Recommendation Report for Planning Permission for Works or Extension to a Dwelling

REF NO: M/136/21/HH

LOCATION: 10 Southdean Drive
Middleton-On-Sea
PO22 7SX

PROPOSAL: Erection of single storey side/rear extension, garage conversion to habitable use and installation of solar panels.

PROPOSED FLOOR PLANS AND ELEVATIONS

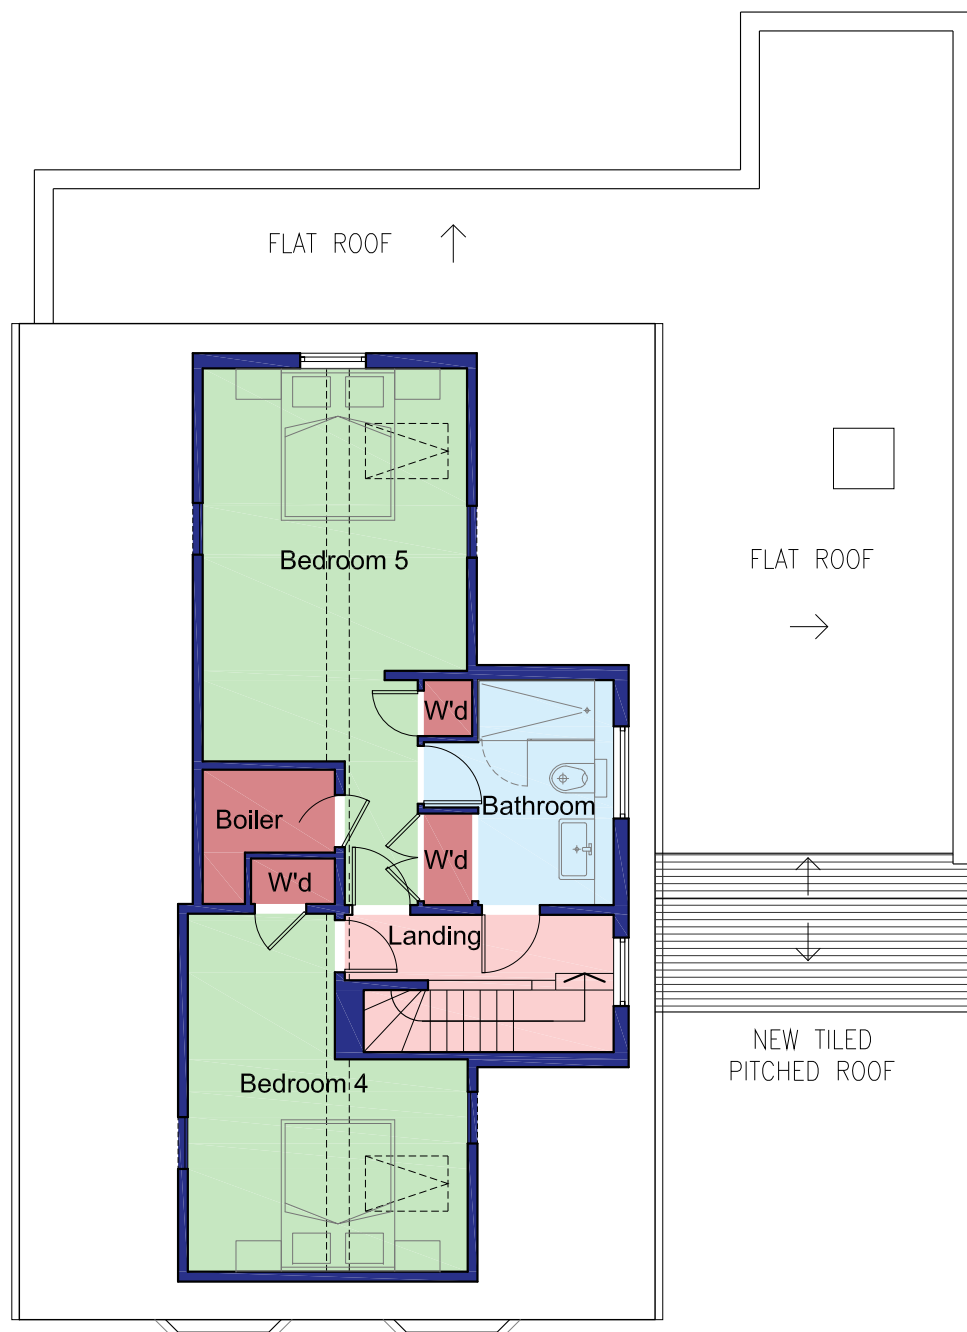
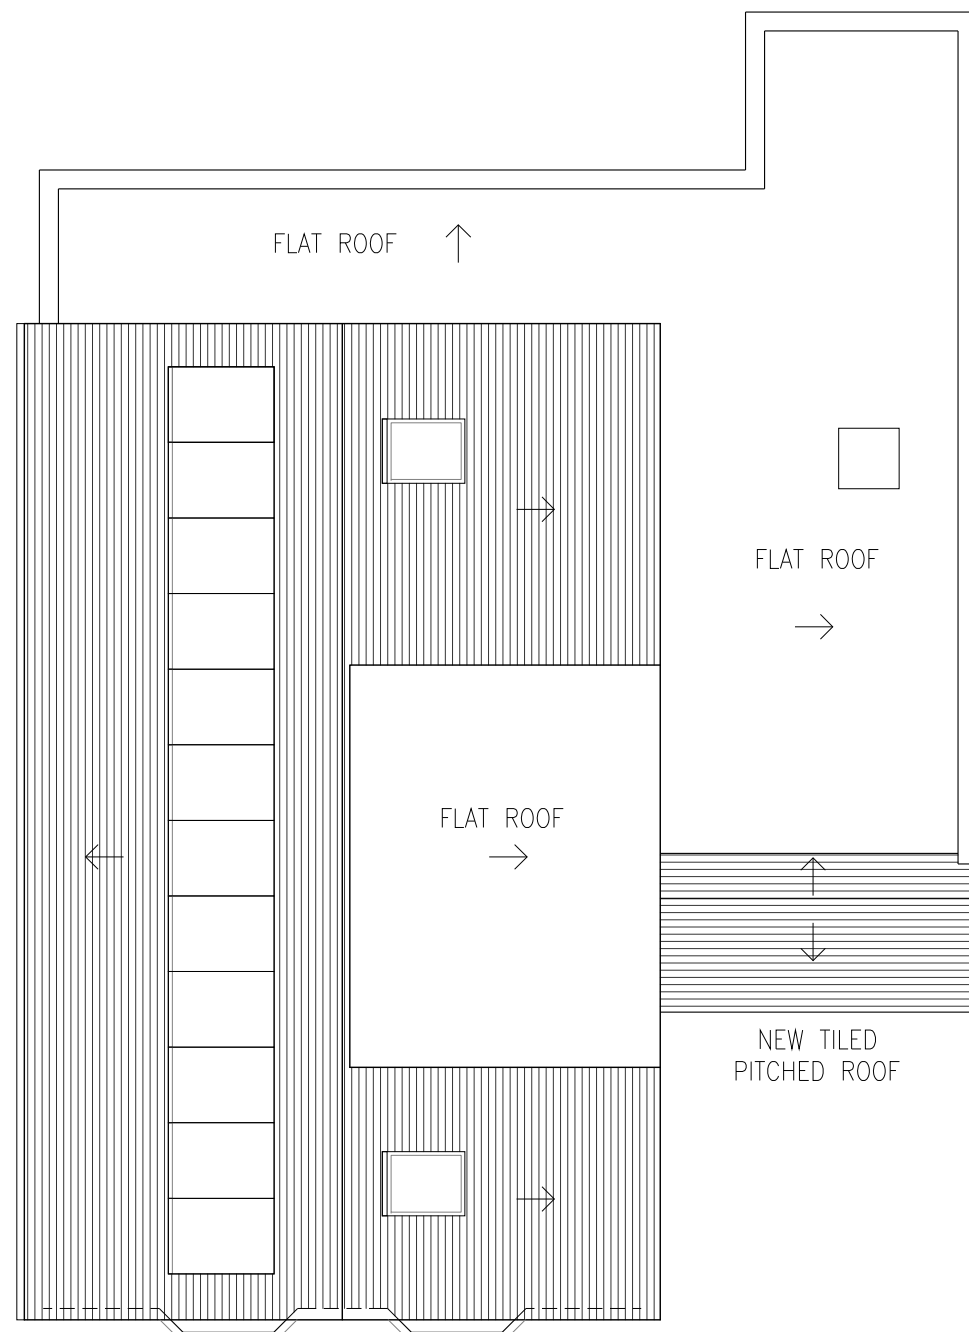
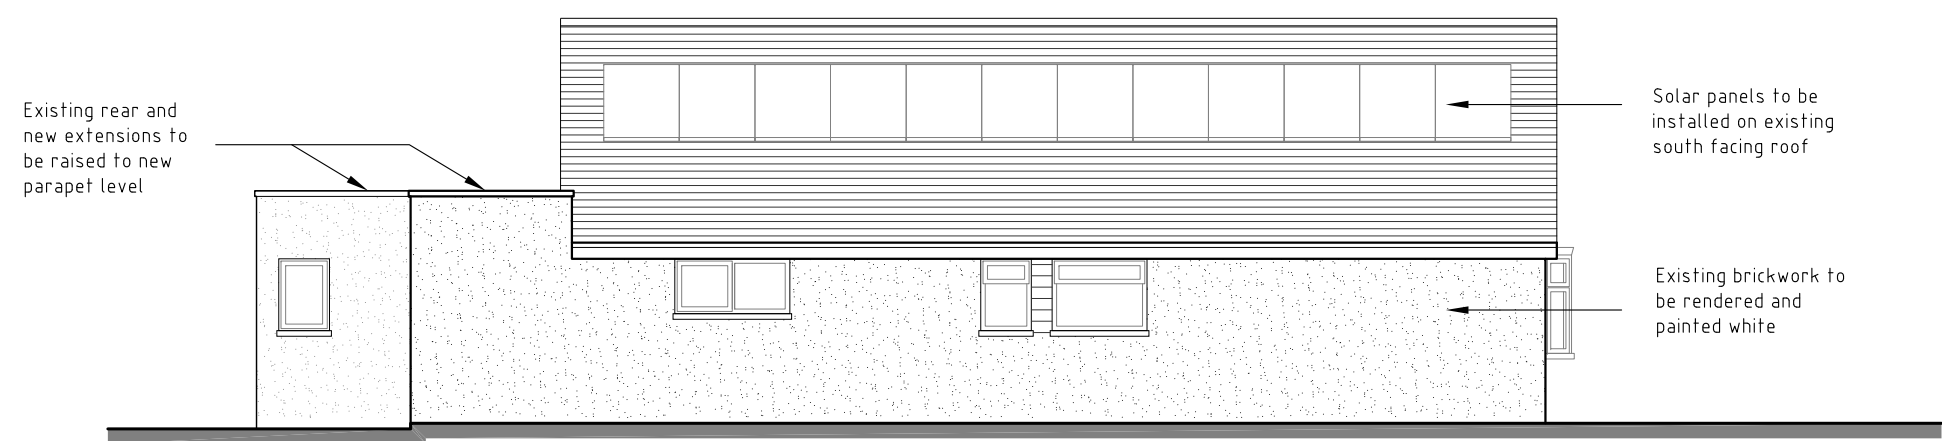
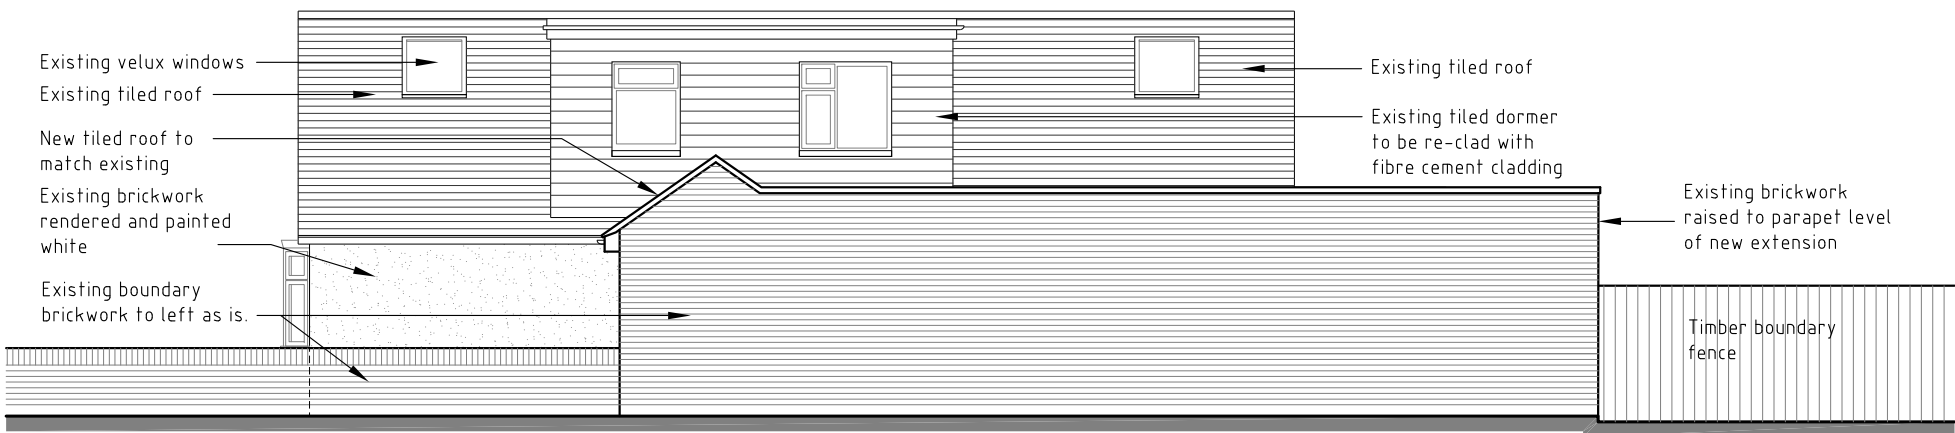
The extension would be at the rear consisting of the re-build of a conservatory style extension and a small section of infill extension. It would also include the building up of the garage walls by 50 cm and the construction of a new garage roof. The installation of solar panels would comply with permitted development rights however it would be an acceptable addition to the roof scape.

The flat roofed extension would only be a marginal increase in the size of the existing garage and as such it would be a subservient and well integrated addition.

The garage will rise from 2.4 metres in height to 2.9 metres in height which is not considered to materially affect the level of light or have an overbearing impact on the neighbouring property 8 Southdean Drive.

The rear extension will not adversely impact any of the neighbouring properties because it would only involve a 15 cm rise in the roof height of the existing extension along the boundary with no.12 Southdean Drive, the neighbouring bungalow.
